LETTER: Lighting Plan for proposed development at Harbour Point, Bray, Co. Wicklow.

Dr Tina Aughney
Bat Eco Services

In 2022, Atkins requested a review of the lighting plan for the proposed development (Phase 1, Coastal Quarter). In the bat assessment report, mitigation measures relating to lighting was presented in detail in order to reduce potential impact on local bat populations. These mitigation measures were in accordance with the BCT Lighting Guidelines (2018).

Title		PROPOSED PUBLIC LIGHTING LAYOUT - SHEET 1 OF 2			
Original Scale	1:500 at A1 1:1000 at A3	Design/Drawn	RRT	Checked	AK
Date	02.09.22	Date	02.09.22	Date	02.09.22
Status	P	Drawing Number	5214419-ATK-01-ZZ-DR-EE-1301	Rev	P01

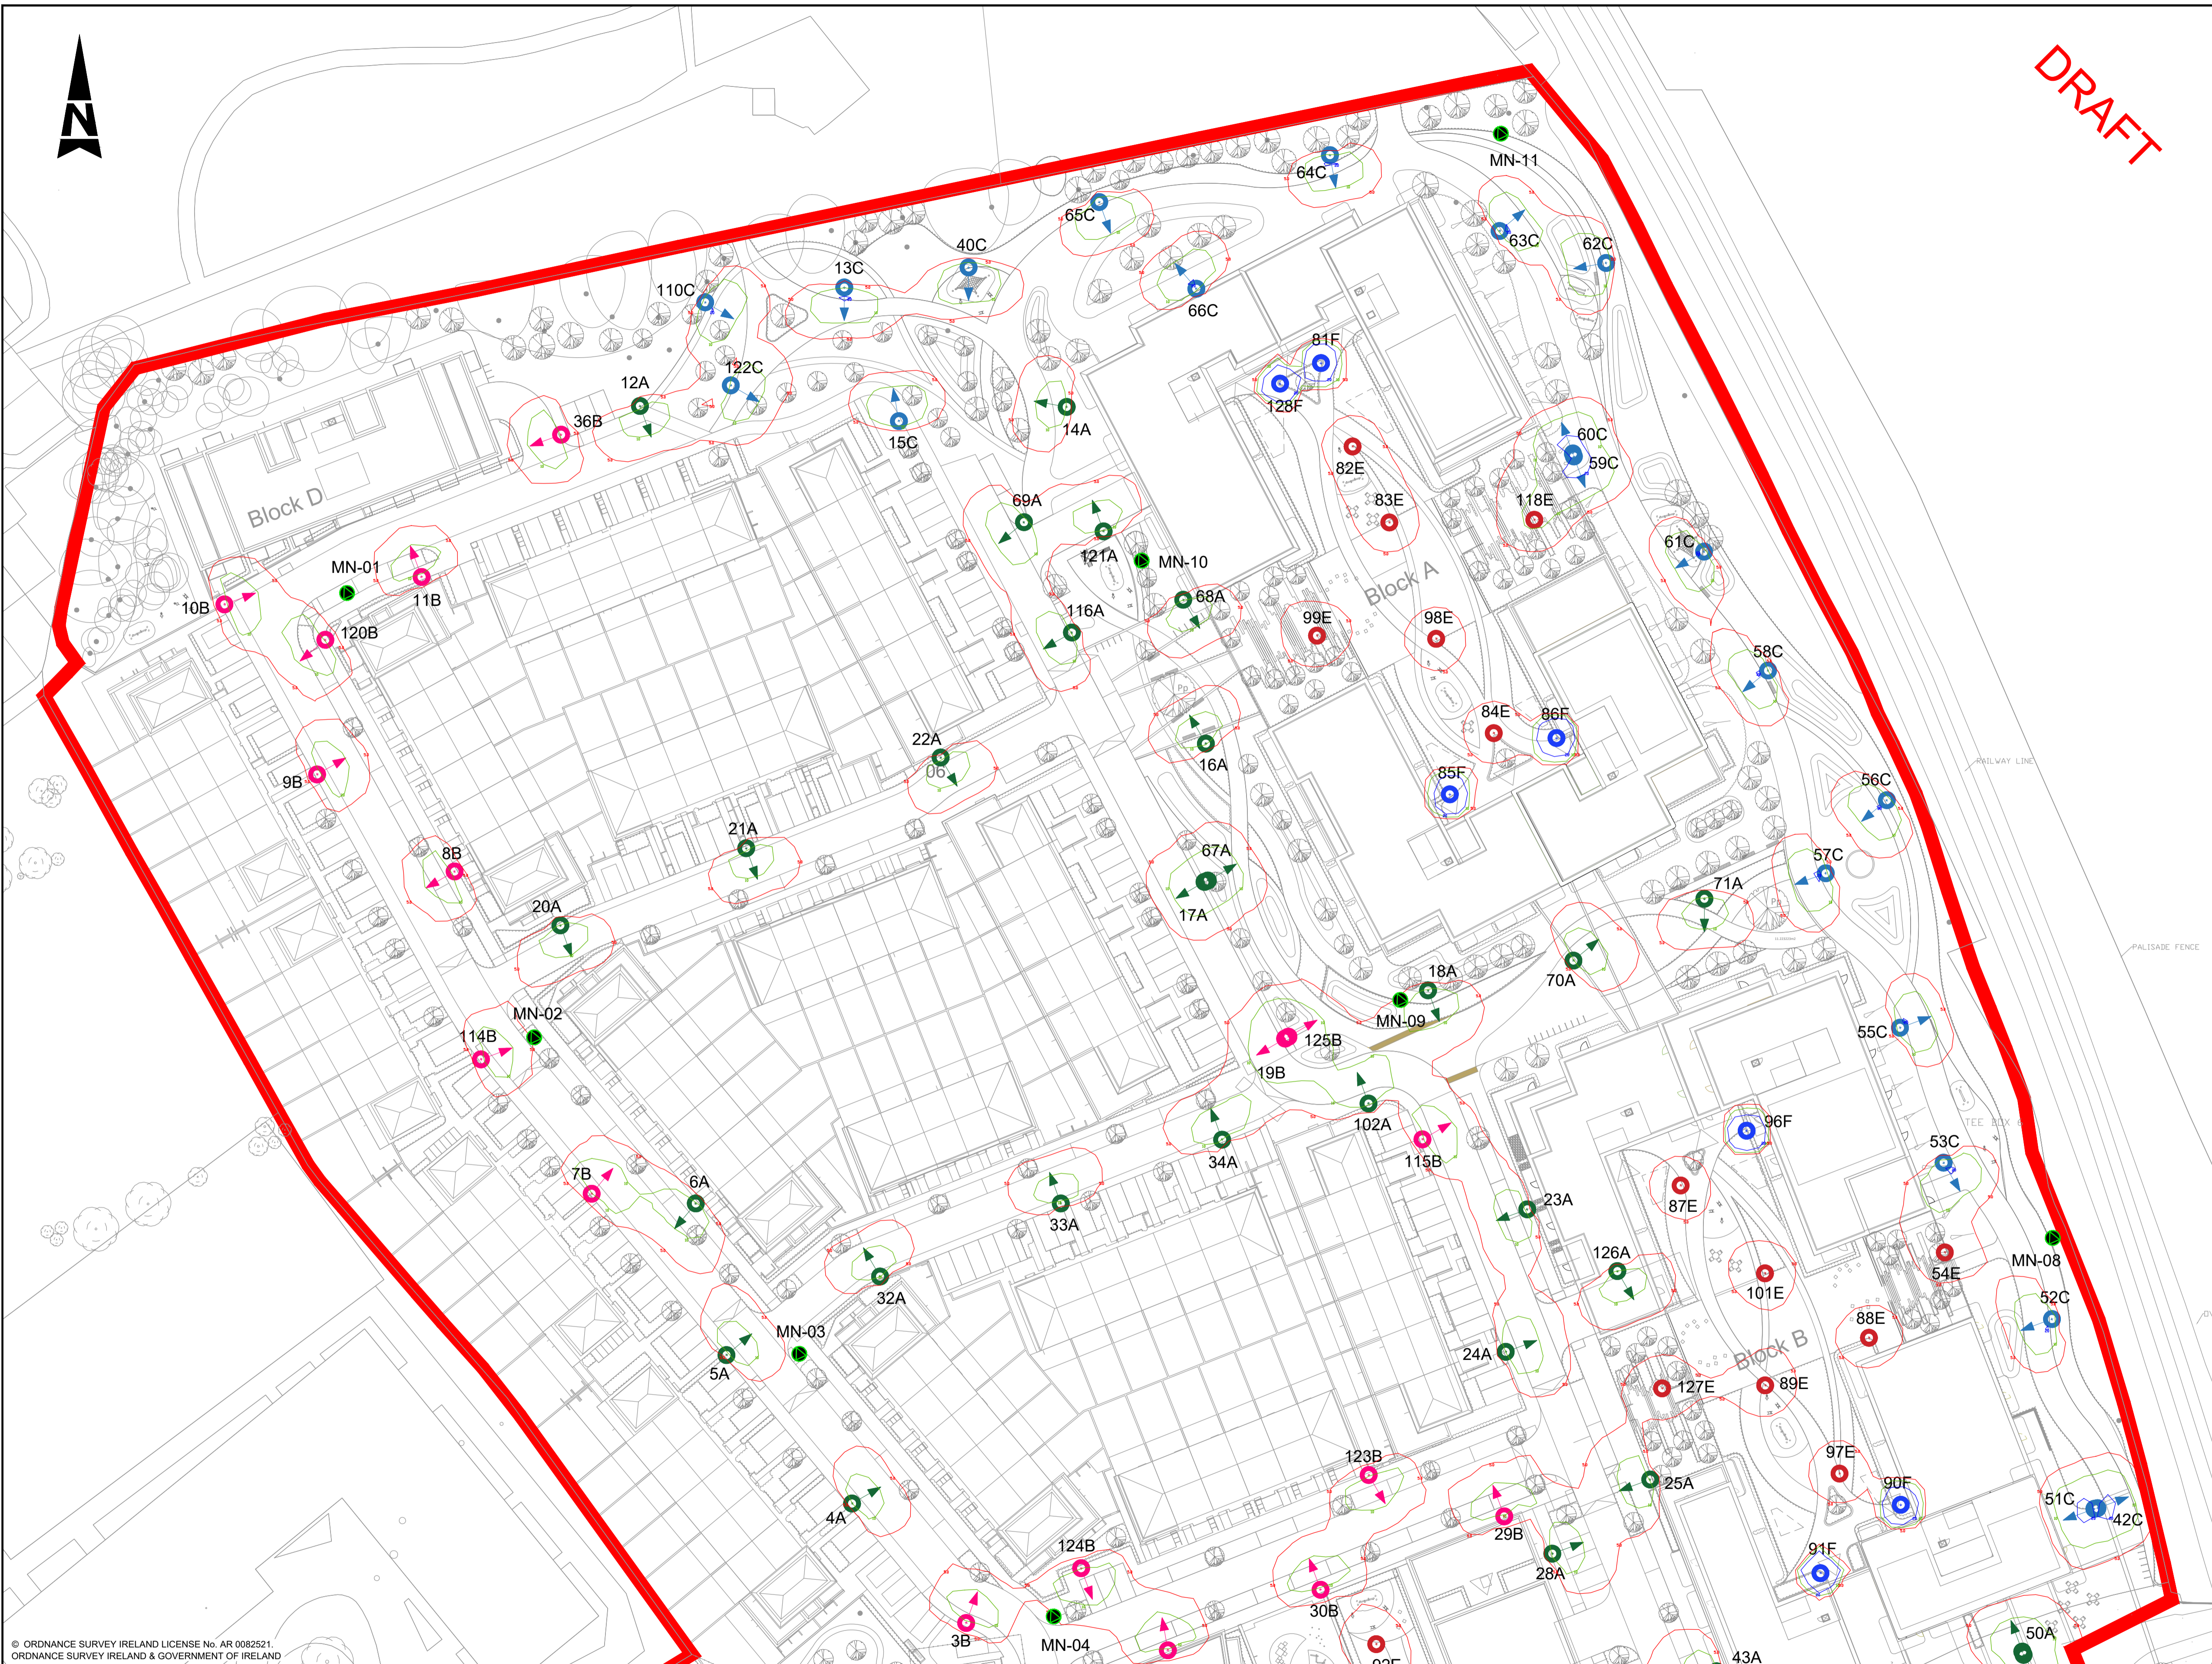
As part of this review, the outdoor lighting report (dated 1/7/2022) was examined. Luminaire D and F have a Kelvin value of 3,000 Kelvins, which exceeds the Kelvin value recommended by the BCT Lighting Guidelines. All other luminaires meet the BCT Lighting Guidelines.

The Horizontal illuminance map indicates that average LUX level is 5.52 (range 1.09 to 22.50). The illuminance map indicates that the lighting spill is controlled to be 0.1 LUX along the majority of the boundary of the proposed development. All European bat species, including Irish bat species, are nocturnal. Light levels as low as typical full moon levels, i.e. around 0.1 LUX, can alter the flight activity of bats (Voigt *et al.* 2018). Any level of artificial light above that of moonlight can mask the natural rhythms of lunar sky brightness and, thus, can disrupt patterns of foraging and mating and might, for instance, interfere with entrainment of the circadian system. Therefore it is important that landscaping, to act as a buffer, is considered for areas where lighting spill is greater than 0.1 along the boundary of the proposed development (e.g. eastern boundary).

Due to the pattern of the proposed lighting plan, the internal area of the development are unlikely to be accessed by local bat populations as lighting essentially acts as a barrier to commuting and foraging bats. Therefore it is essential that the overall proposed development scheme for Harbour Point considers the following points:

- Areas of suitable bat habitat remaining in the landscape post development and are located along the boundary of the proposed development are part of a continuous dark zone that allows nocturnal animals, including bats, to travel during the hours of darkness. These dark zones should be connected to the wider landscape such as the River Dargle and the People's Park located south of the proposed development, woodland are to the north and to the coastal area to the east of the proposed development.

- Greater consideration in lighting plans to use dynamic lighting controls to reduce lighting outside the prime hours of human activity (Voigt *et al.*, 2018).

In consultation with Atkins, Atkins confirmed that the points presented above have been incorporated into the lighting design and that the shortest column height, without conflicting with engineering designs, have been set at 6m.
